Meeting note

Project name	Net Zero Teesside Project
File reference	EN010103
Status	Final
Author	The Planning Inspectorate
Date	15 September 2021
Meeting with	Net Zero Teesside Power Limited and Net Zero North Sea Storage Limited
Venue	Telecon
Meeting objectives	Project Update Meeting
Circulation	All attendees

THE NET ZERO TEESSIDE PROJECT

ADVICE FOLLOWING ISSUE OF DECISION TO ACCEPT THE APPLICATION FOR EXAMINATION

TITLE
WORKS PLAN. KEY PLAN
DOCUMENT REF. 4.4
WORK NUMBER 1 - ELECTRICITY GENERATING STATION

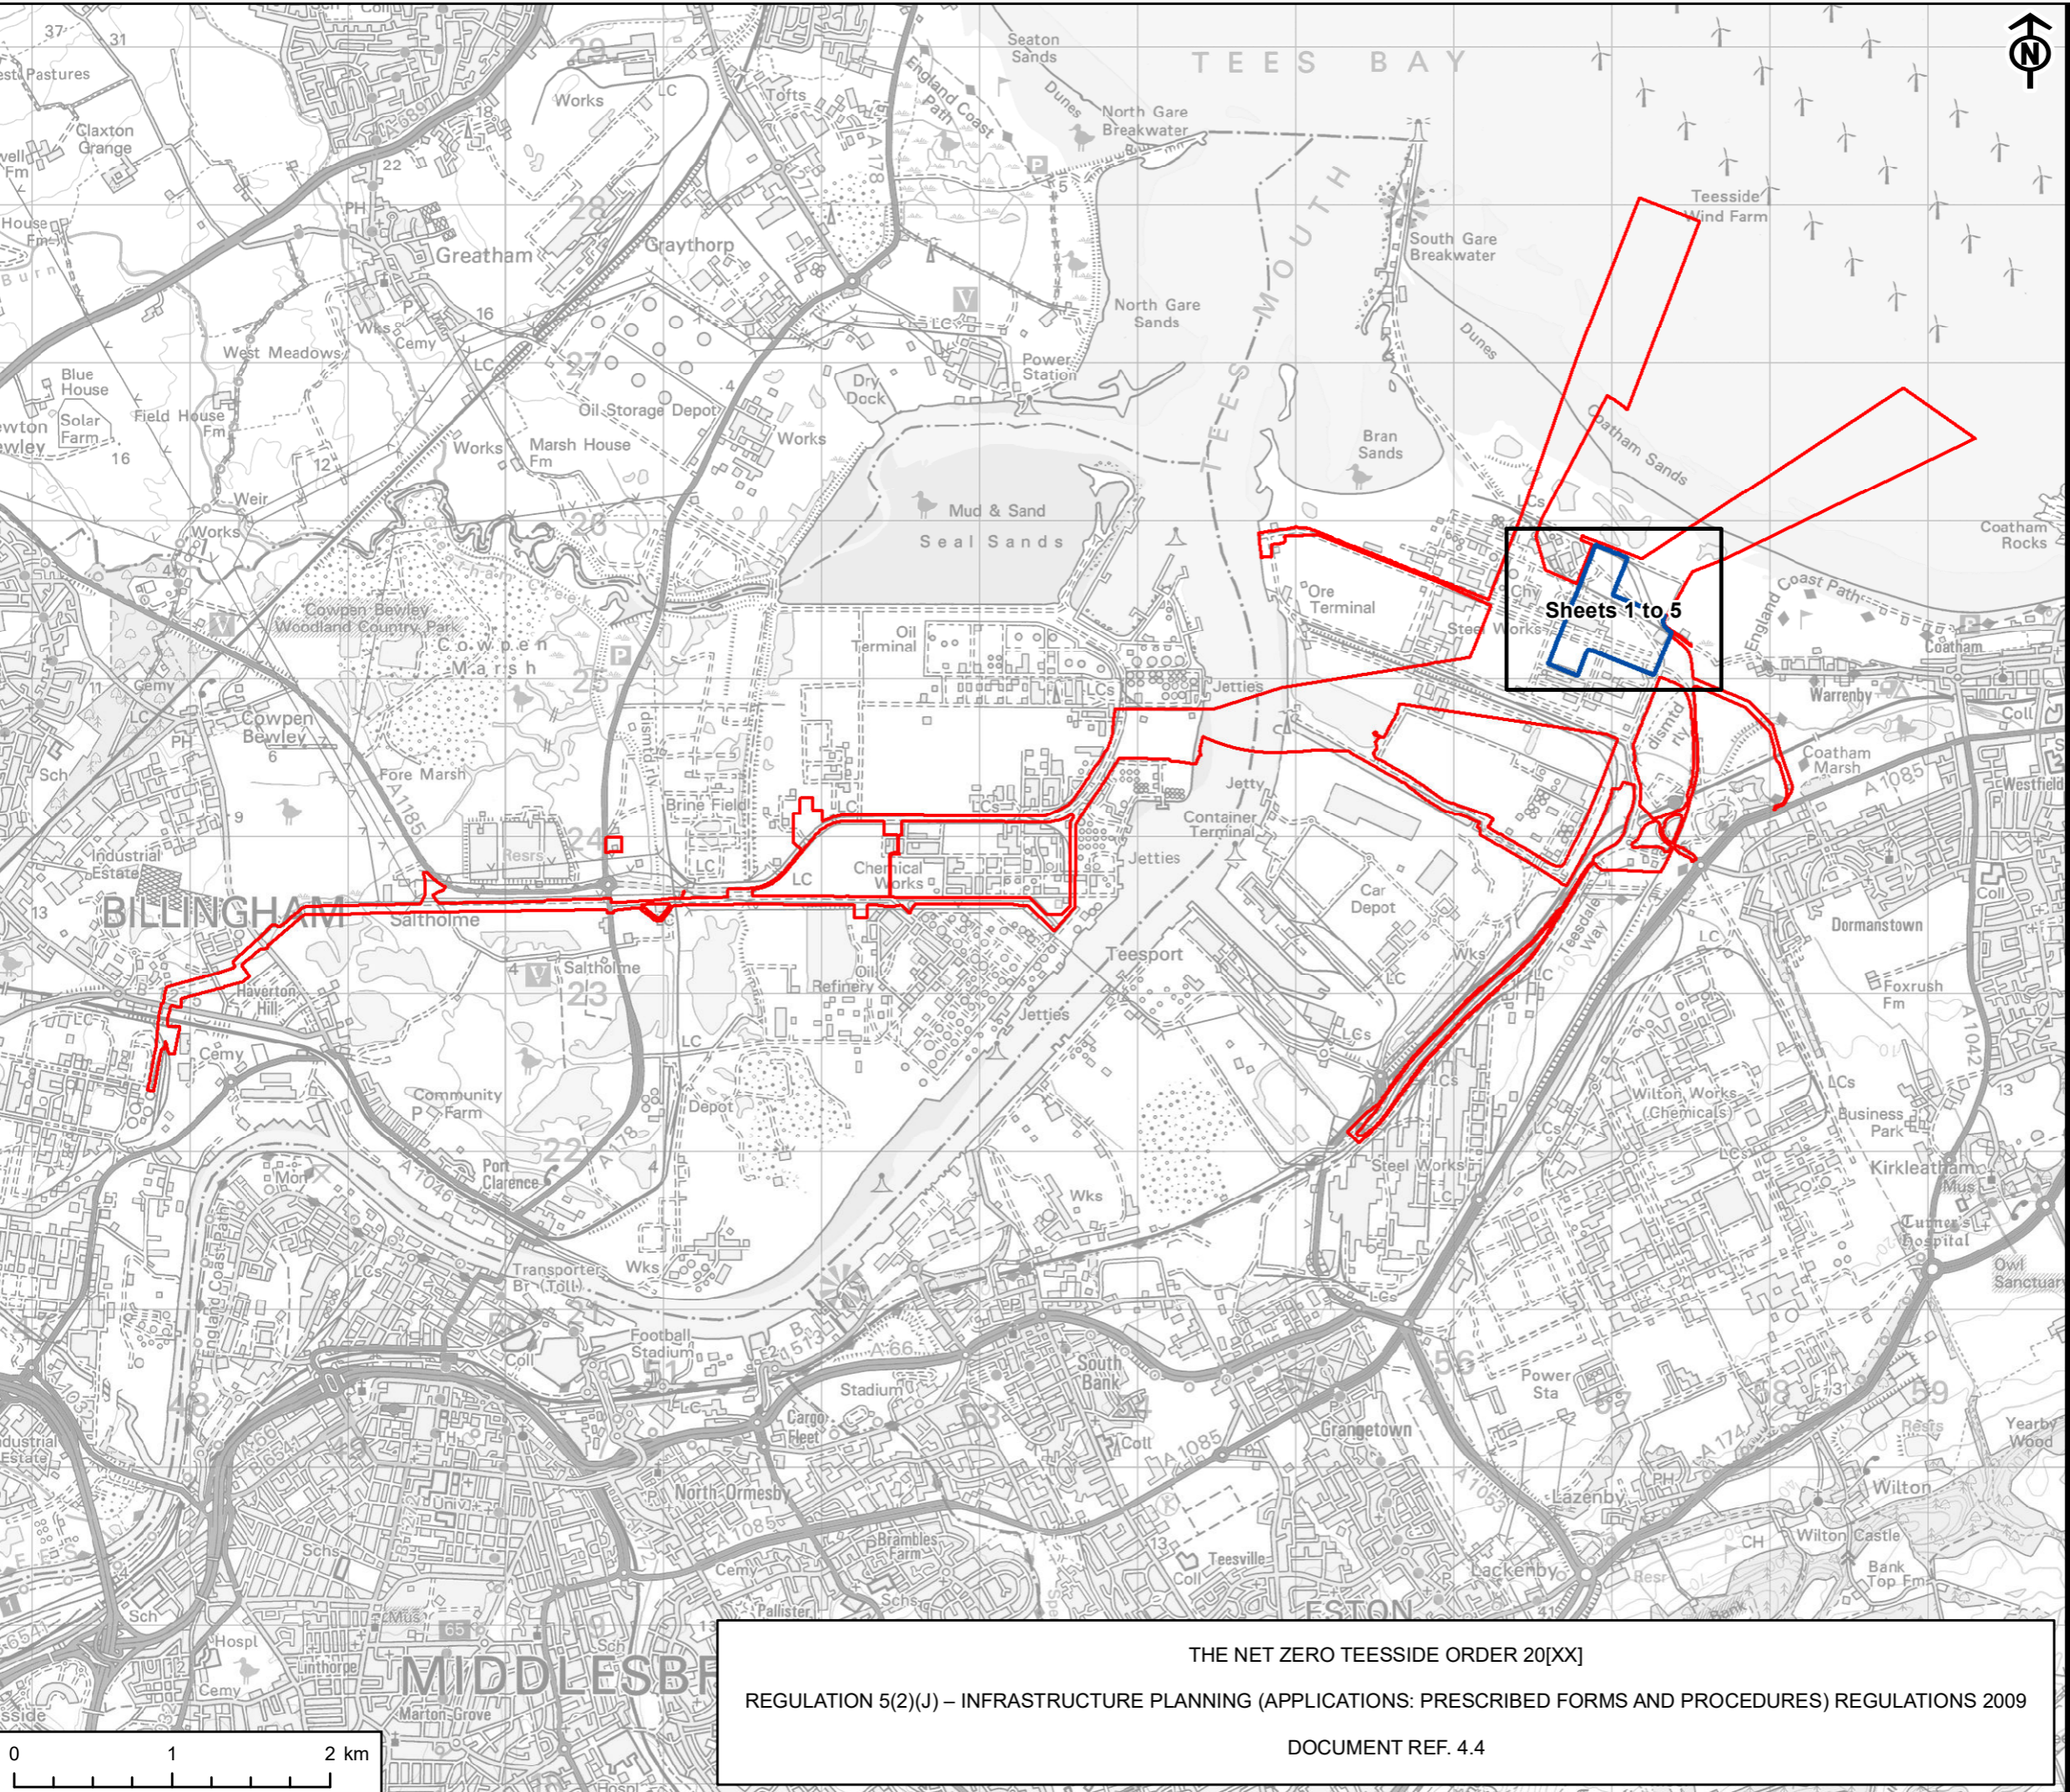
Work No. 1 'subsection e'

The Inspectorate asked the Applicant to clarify what the works in this section would relate to, as it appears that the elements could be located anywhere within the Work No. 1 footprint.

The Inspectorate commented that the placing of these elements is likely to be an issue at the examination. The drafting of the DCO, with regard to Work 1, subsection (e) may also be queried by the ExA.

The Applicant confirmed that this is intentional; these elements final location are not yet known and the approach used is to provide flexibility. The Environmental Statement has taken the elements within Work 1 into account, but they do not influence the assessments due to the minor nature of the elements. An updated Explanatory Memorandum will explain the elements and demonstrate that these are captured in the worst-case scenario.
